# Picton High School

## Proposed Roadworks Road Safety Audit

## Proposed Roadworks Road Safety Audit

This report has been prepared on behalf of GHD to present road safety audit findings resulting from the proposed roadworks associated with the expansion of Picton High School.

Project Name	PICTON HIGH SCHOOL REDEVELOPMENT PICTON, NSW 2571
Drawing Title	ARGYLE STREET TRAFFIC CONTROL DEVICE SKETCH PLAN

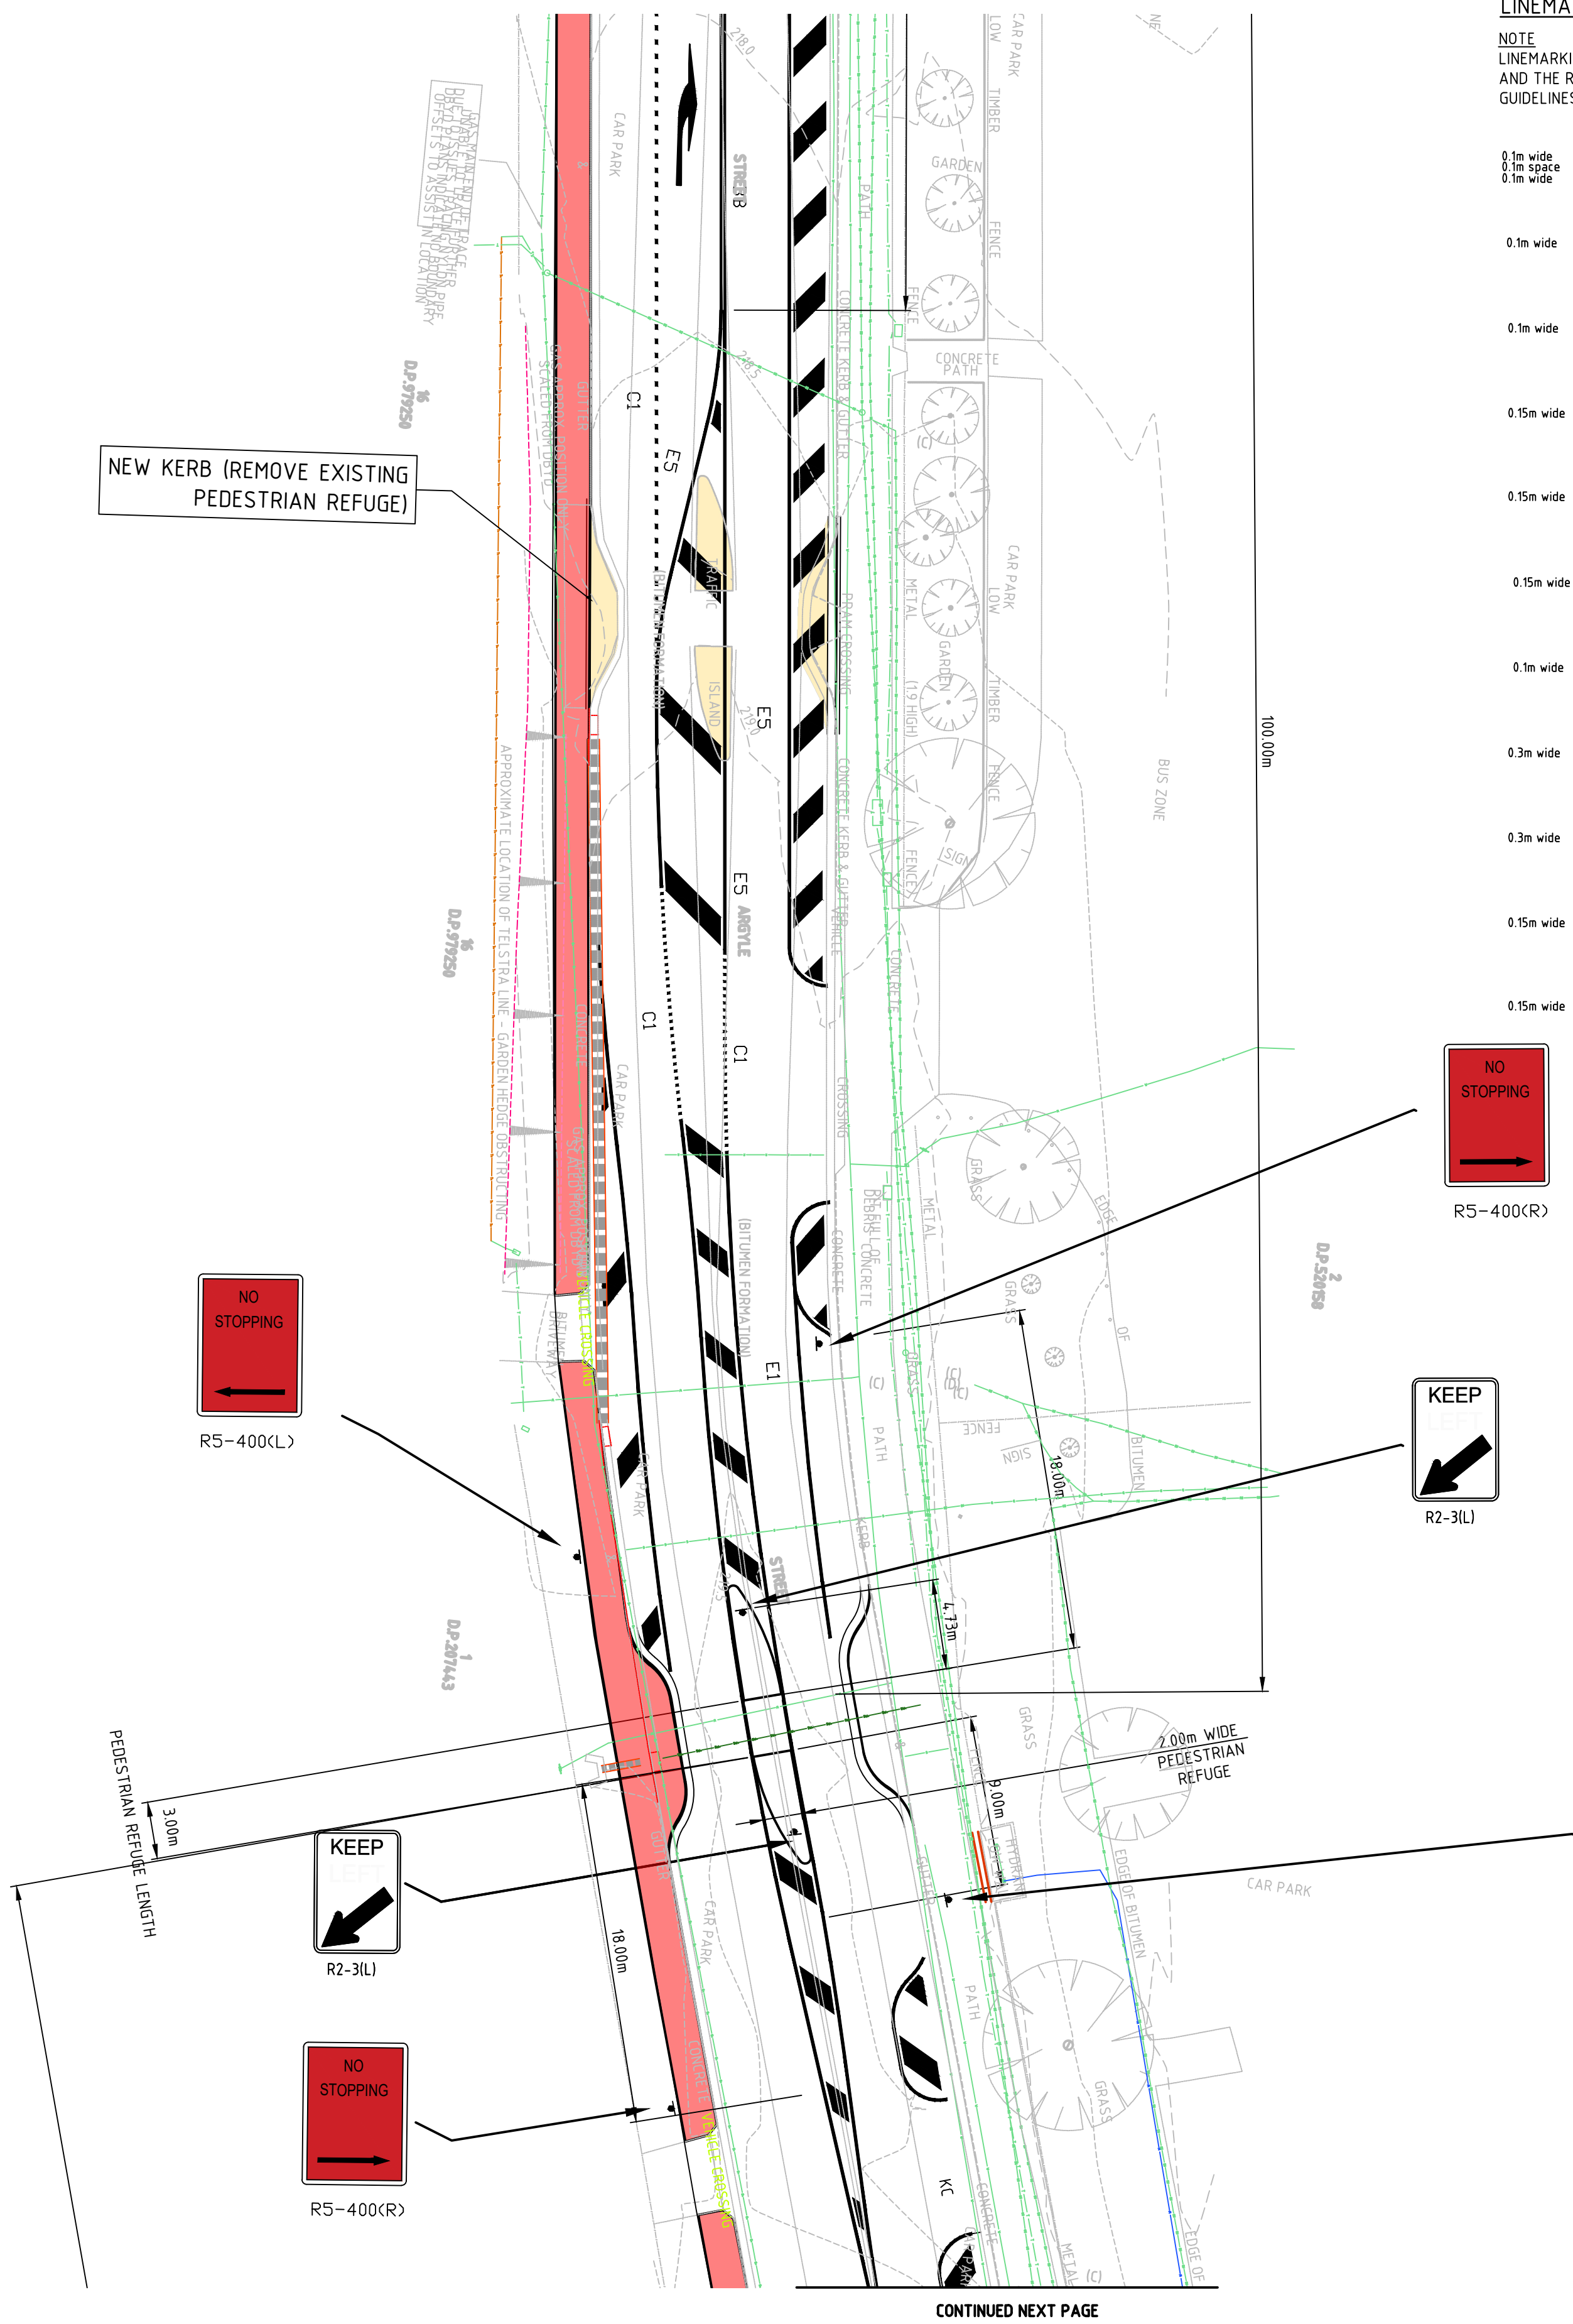
Item No.	Descriptions of Findings	Photo	Likelihood	Severity	Risk Rating
1.	<p>All pedestrians walking along Argyle Street will need to divert into the site due to the 1200mm fence barriers and the removal of the footpath between the access/egress. Pedestrians may not be sure if they are trespassing into private land owned by the school. Consequently, pedestrians may walk into the road outside the fence which has potential for collisions with vehicles.</p> <p>N.B. The plans are not consistent – the Traffic &amp; Security Design shows the footpath between the entrance / exit retained whilst the Site Context Plan shows this footpath replaced with a wider verge and no footpath but shows no fence.</p>				
2	<p>Provision of a 70m right turn bay for the Argyle Street to School Bus Interchange right turn movement and a new wide painted median in Argyle Street results in the removal of a number of 2 minute on-street parking spaces on the west side of Argyle Street.</p> <p>These car spaces are currently used by parents to drop off and pick up students.</p> <p>Insufficient parking supply may result in motorists' parking/ stopping in unsafe locations.</p>		Occasional	Moderate	Medium

Item No.	Descriptions of Findings	Photo	Likelihood	Severity	Risk Rating
3	<p>Observations have shown that motorists often give priority to pedestrians at the existing pedestrian refuge across Argyle Street which may result in some students becoming conditioned to receiving priority. This may not always be the case resulting in pedestrian conflicts</p> <p>Consideration should be given to other pedestrian crossing treatments where pedestrians have priority over motorist.</p>		Highly Probable	Moderate	High

Item No.	Descriptions of Findings	Photo	Likelihood	Severity	Risk Rating
4	<p>Two minute on-street parking on the east side of Argyle Street should be maintained or 'No Parking' signage be installed.</p> <p>Provision of 'No Stopping' signage would result in motorists not being permitted to park/ wait in this area.</p> <p>Given the lack of on-street parking in close proximity to the school entrance, children are likely to be dropped off within school grounds at the new 'taxi pick up/ drop off' area thus mixing pedestrians with traffic which could result in conflicts.</p>		Occasional	Moderate	Medium

Item No.	Descriptions of Findings	Photo	Likelihood	Severity	Risk Rating
5	<p>A dedicated right turn bay is not provided for the right turn movement from Argyle Street into the new access into the staff car park.</p> <p>Lack of a right turn bay may result in rear end incidents.</p>		Occasional	Minor	Low
6	<p>No pedestrian footpath facilities are provided on the west side of Argyle Street south of the proposed pedestrian refuge facility which is where students are likely to walk to reach parked cars</p> <p>The lack of a surfaced footpath can result in pedestrians tripping over.</p>		Occasional	Minor	Low

Item No.	Descriptions of Findings	Photo	Likelihood	Severity	Risk Rating
7.	Left turn auxiliary lanes are not provided on approach to the School bus interchange or staff car park. Lack of left turn auxiliary lanes may result in motorists decelerating within the Argyle Street southbound carriageway which may result in rear end incidents.		Occasional	Minor	Low
8.	The proposed bus interchange has capacity for six buses.  Buses do not appear to have sufficient taper in/ taper out length to enable bus drivers to enter and exit independent of other buses.		Note Only

Item No.	Descriptions of Findings	Photo	Likelihood	Severity	Risk Rating
9.	The proposed scheme does not propose any cycle facilities.  A lack of cycle facilities connecting may result in cyclists using the footpath or road which in turn may result in collisions.		Occasional	Minor	Low
10.	Pedestrians will undertake the shortest and most direct path between the school and bus pick/ drop off zone.  Pedestrians are likely to cross the new school access even though no pedestrian facilities are proposed which is likely to result in pedestrian collisions.		Occasional	Minor	Low
11.	Wonga Road is a public road. The RMS warrant for a pedestrian crossing is unlikely to be satisfied.		Note only.
